Outer Dowsing Offshore Wind

5.1 Consultation Report

Annex 5.1.4B Section 42
Consultation Responses

Date: July 2024

Figure 13.9 Records and Geoaerchaeological Features within the Array Area

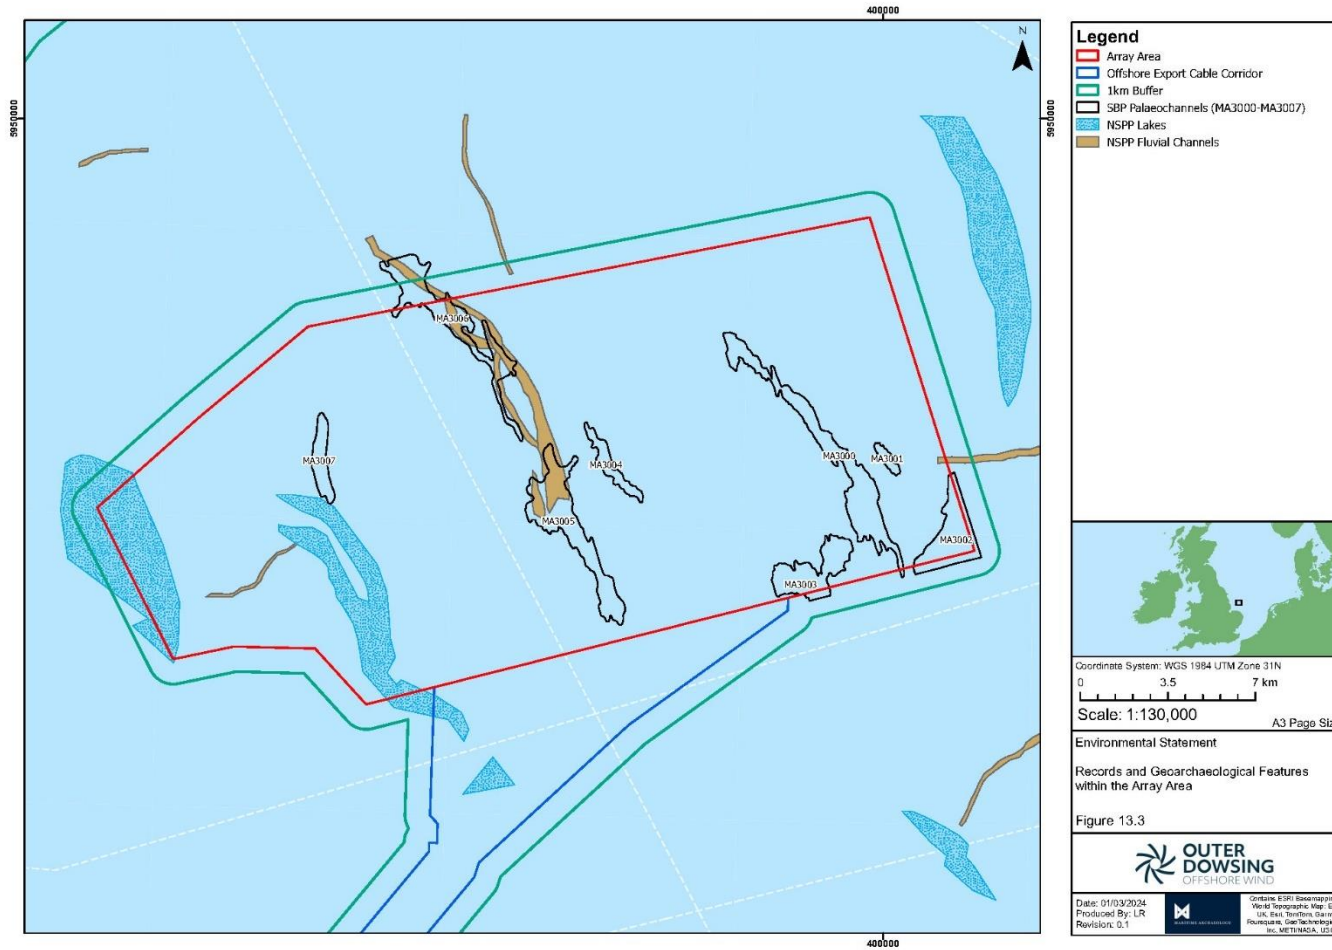
48	Historic England	P2_11	<p>Table 13.7 (Outline Deposit Model) - this is not a deposit model, it lists, alphabetically, geological units without any spatial relationship to the proposed development location. It is therefore not readily possible to relate this information to Figure 13.9 which utilises information derived from the North Sea Palaeolandscapes Project by V. Gaffney et al., (2007). It is also conspicuous that no attention is given to geotechnical ground-truthing as will be necessary to effectively guide this proposed project. In the absence of any information regarding palaeo-environmental potential in the ECC, we cannot offer any further comment or advice at this stage.</p> <p>We note subsequently in the same document that the ‘Deposit Model’ is provided (Volume 1, Chapter 13 - Marine and Intertidal Archaeology, Document No. 6.1.13) and it states:</p> <p>13.8.12 At this time there have been no offshore geotechnical surveys undertaken for archaeological assessment, however, these are planned post consent. Geoarchaeological sub-sampling will be included and informed by the results of the sub-bottom data analysis and previous geoarchaeological assessment of the area.</p> <p>Regardless of whether dedicated archaeological borehole surveys has yet been undertaken, the opportunity should have been taken to integrate archaeological assessment into any appropriate geotechnical work that was underway.</p>	This Applicant has noted this response.
